**From:** Tom Errico <thomas.errico@tylin.com>  
**To:** Jean Fraser <JF@portlandmaine.gov>  
**CC:** David Margolis-Pineo <DMP@portlandmaine.gov>, Katherine Earley <KAS@port...>  
**Date:** 5/8/2014 8:41 AM  
**Subject:** Westgate Shopping Center -- Dunkin Donuts

Jean - I find the project to be acceptable and that it meets TMP requirements with my final comments noted below.

PICKUP WINDOW TO 25' SETBACK
MENU BOARD TO 25' SETBACK

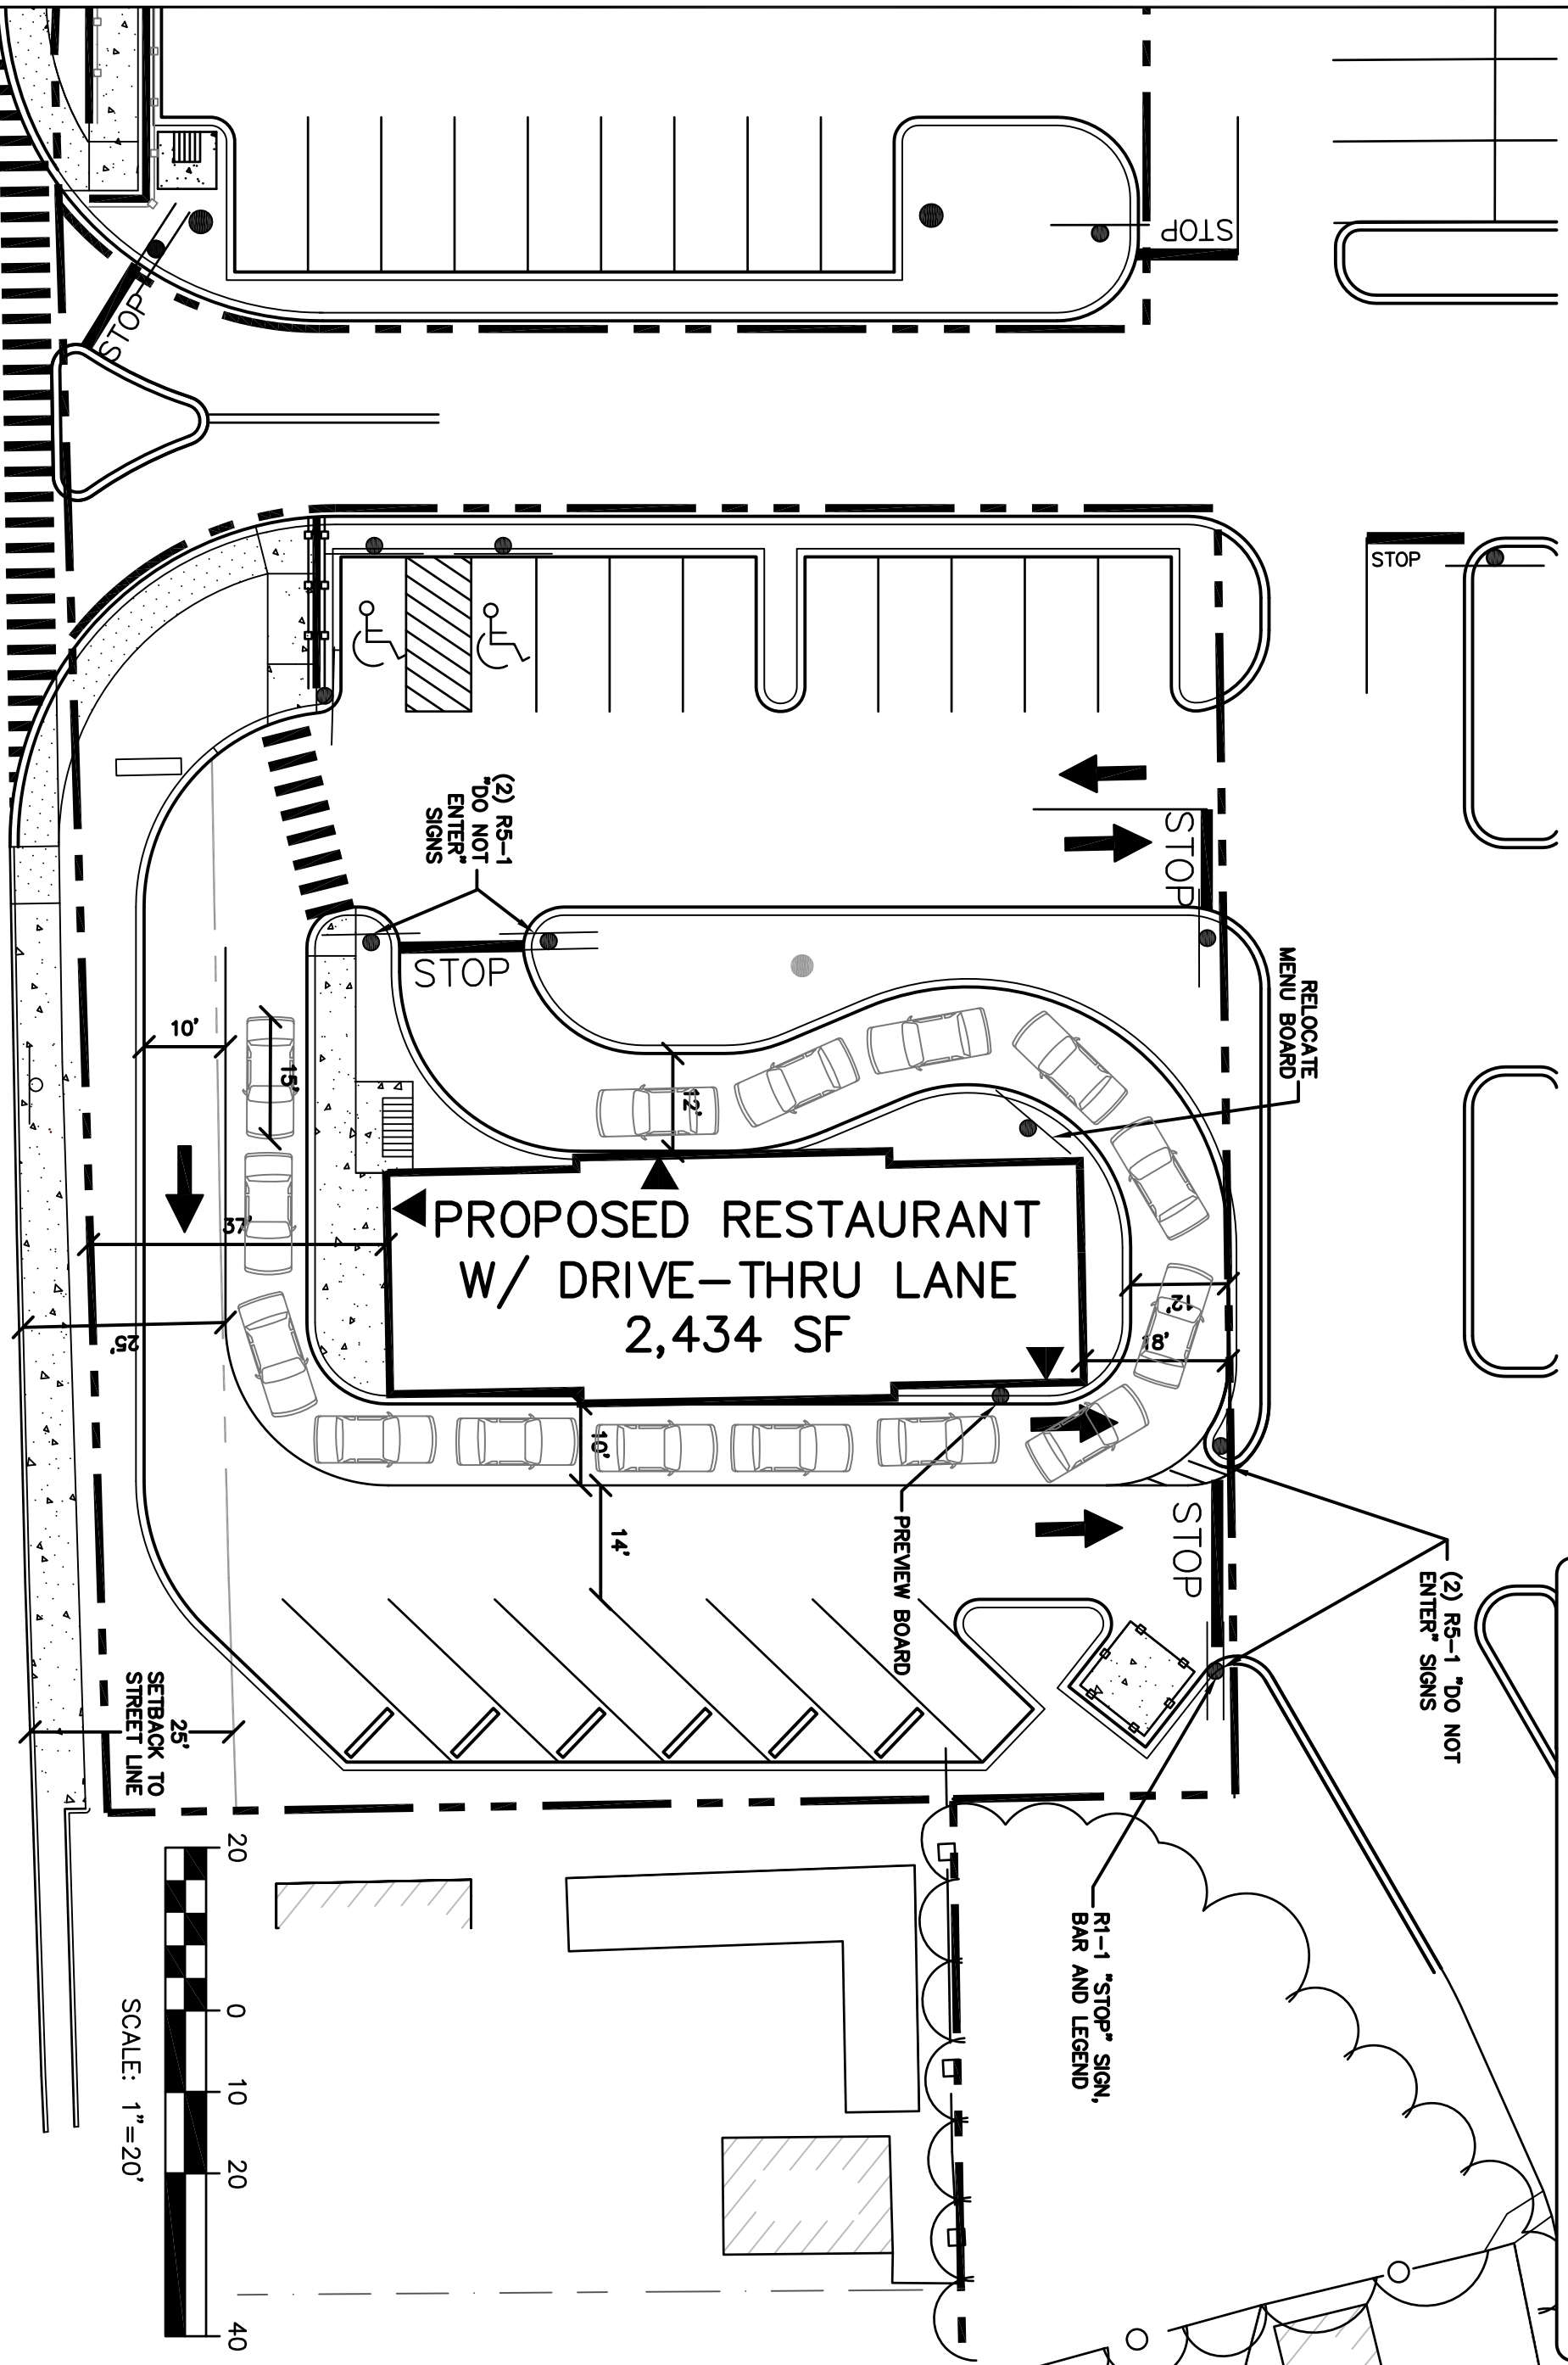
\* I have reviewed the traffic analysis and site plan graphics as it relates to the drive-through lane for the project. In my professional opinion the drive-through will operate safely and is not expected to create any traffic circulation issues. I find site conditions to be acceptable.
